Glyn Rhonwy Pumped Storage Development Consent Order

Action points arising from the Issue Specific Hearing into the Development Consent Order (DCO) held on 9 March 2016

### Indicative Elevations & Section of Penstock Configuration (Revision 1)

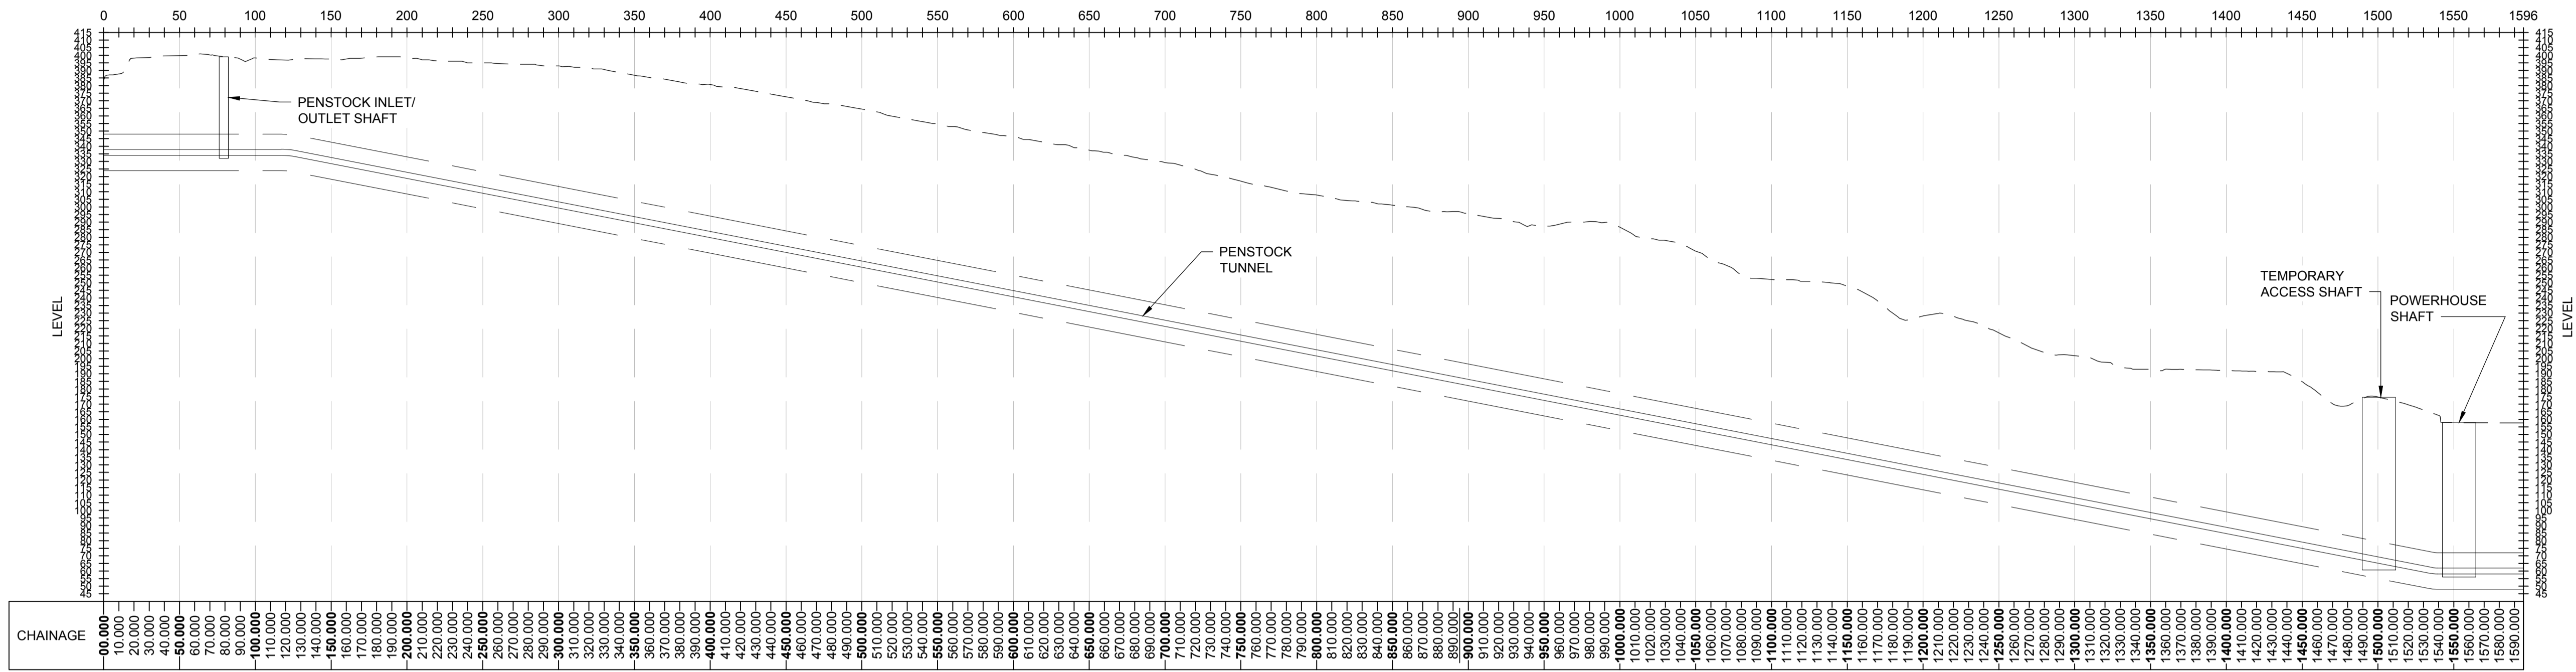
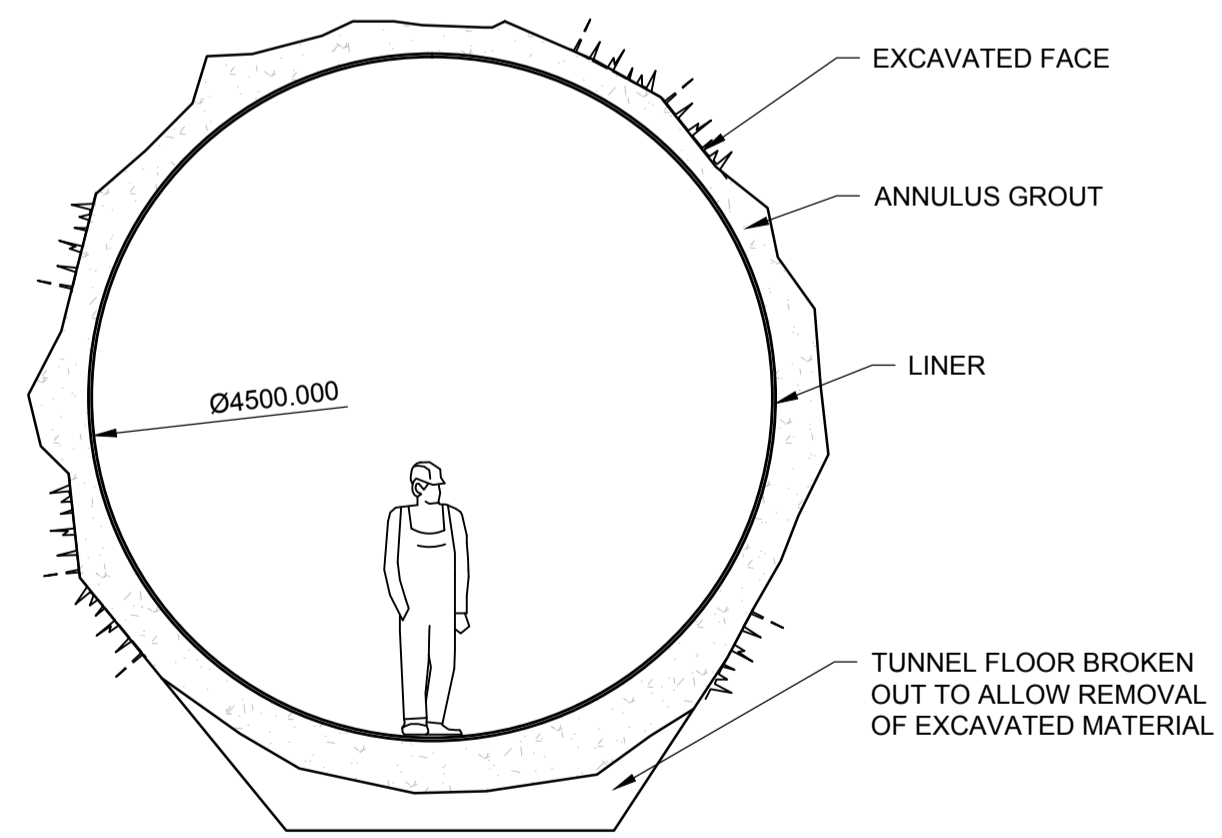
7.	14	Applicant	Consider means of identifying horizontal and vertical limits of deviation on the drawings e.g. by way of a note or table.
8.	15	Applicant	Consider more precisely defining the extended definition of "maintain" by reference to the examples given in the applicant's response, and ensuring consistency between the definition and the ES.
